From: Laura Gibbons [REDACTED]
Sent: 01 February 2022 15:19
To: Planning.Responses [REDACTED]
Cc: Simon Davis [REDACTED]
Subject: RE: Planning Consultation on: Y/185/21/DOC

Engineers Comments Regarding Condition 9

Application No: Y/185/21/DOC

Site Address: Land East of Drove Lane Yapton BN18 0EB

ELEVATION OF HEADWALL
OUTLET FROM END OF DITCH

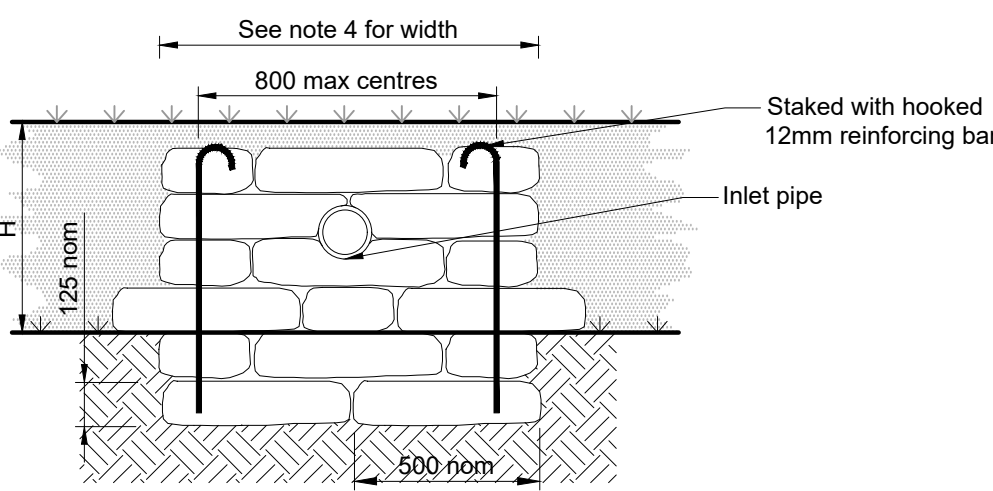
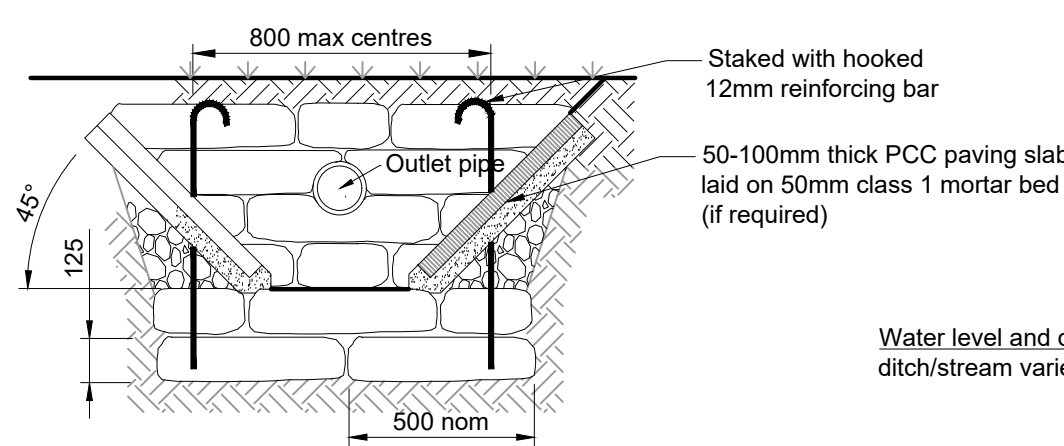
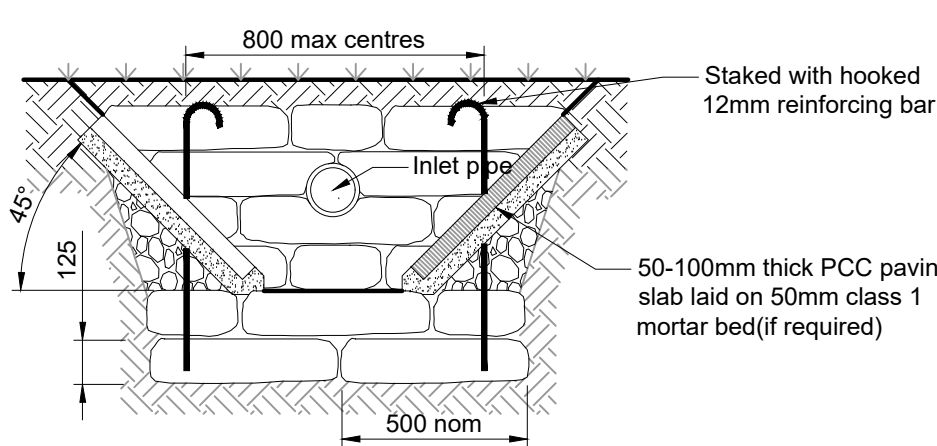
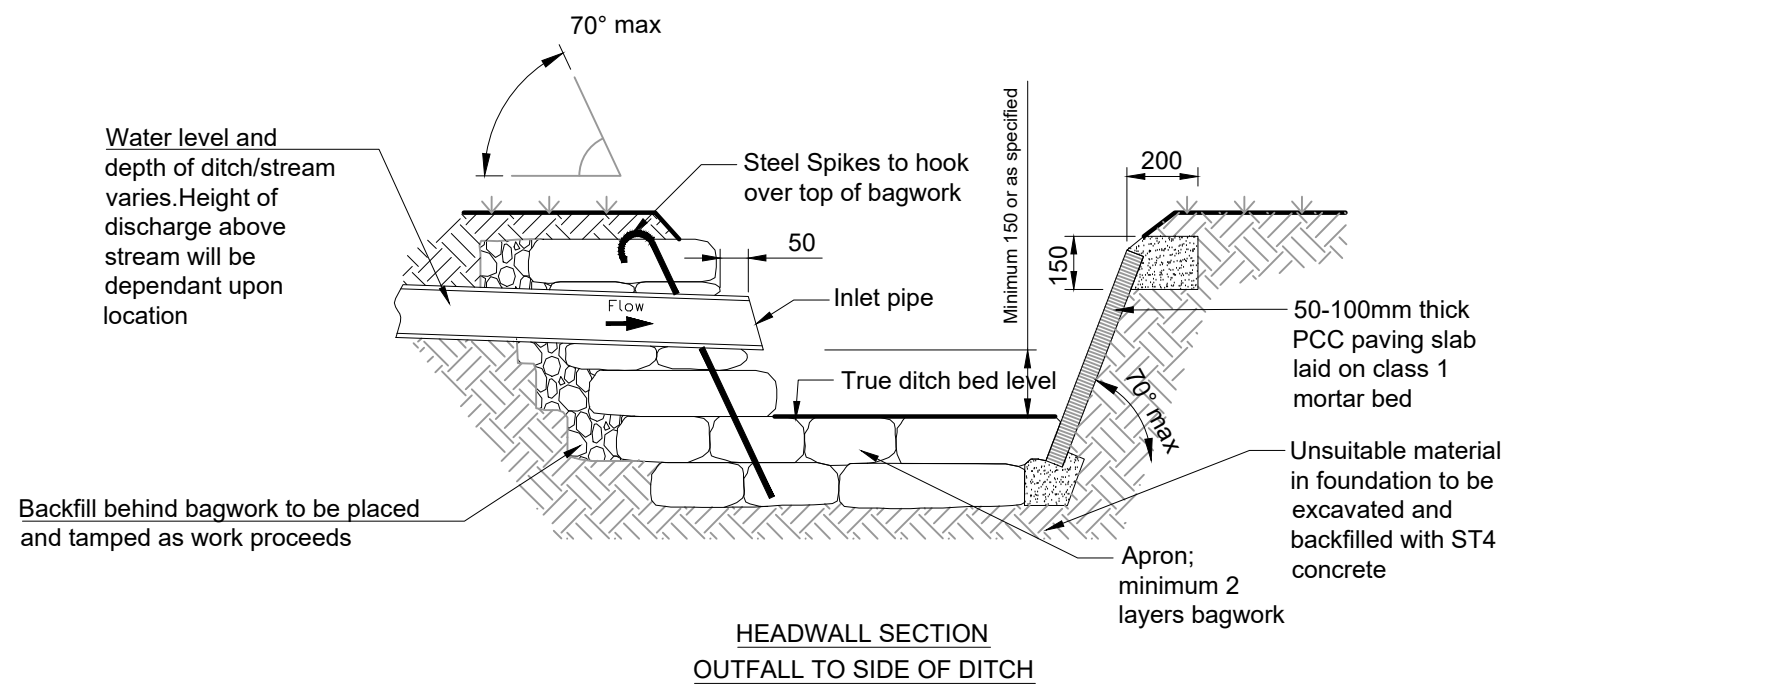
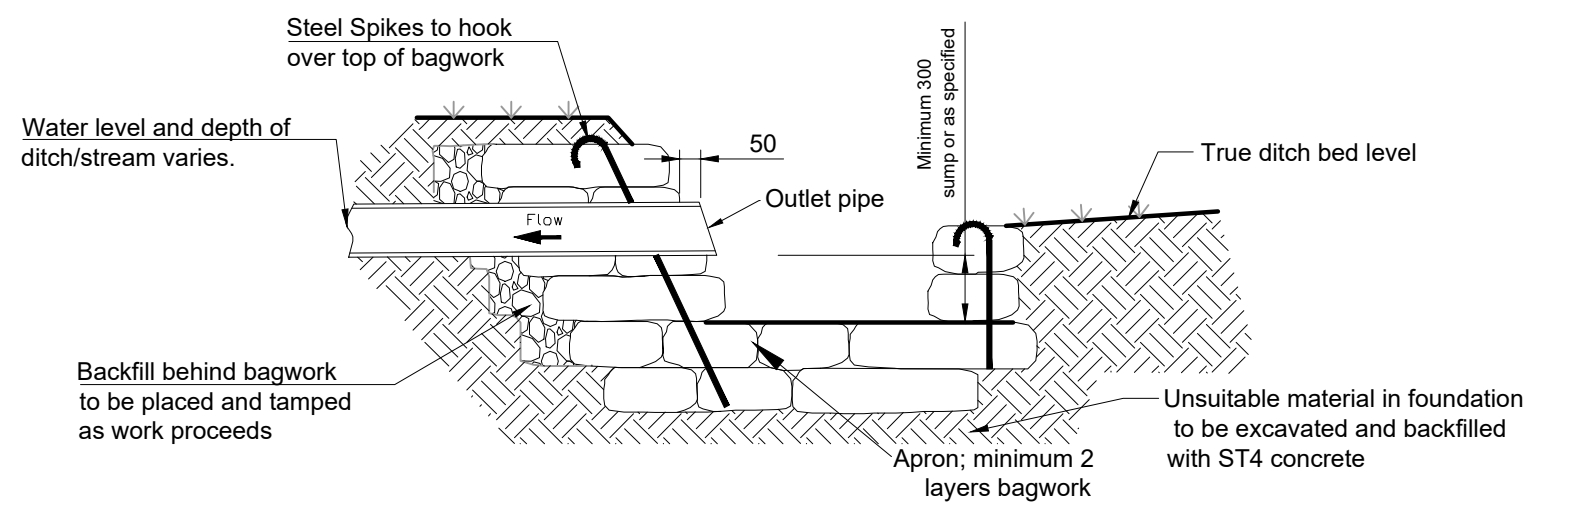
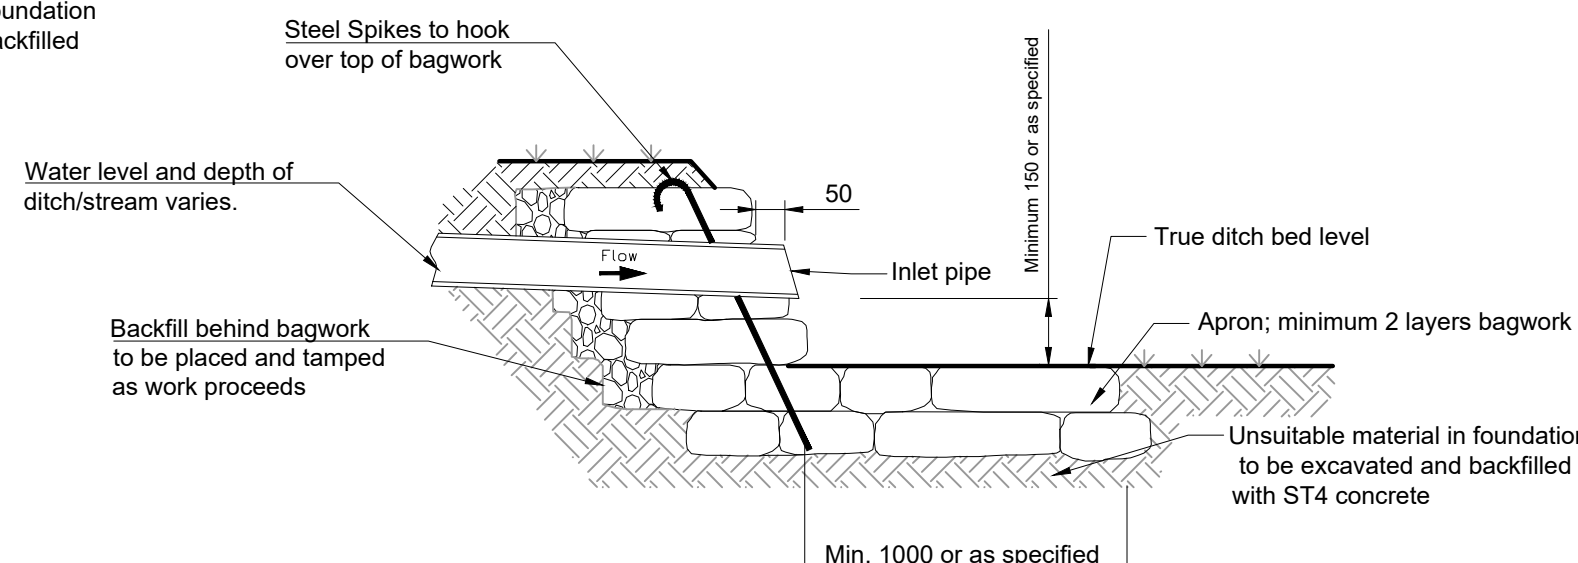
A site specific construction detail drawing of the outfall from the system to the watercourse should be provided. This should be consistent with the land drainage consent detail.
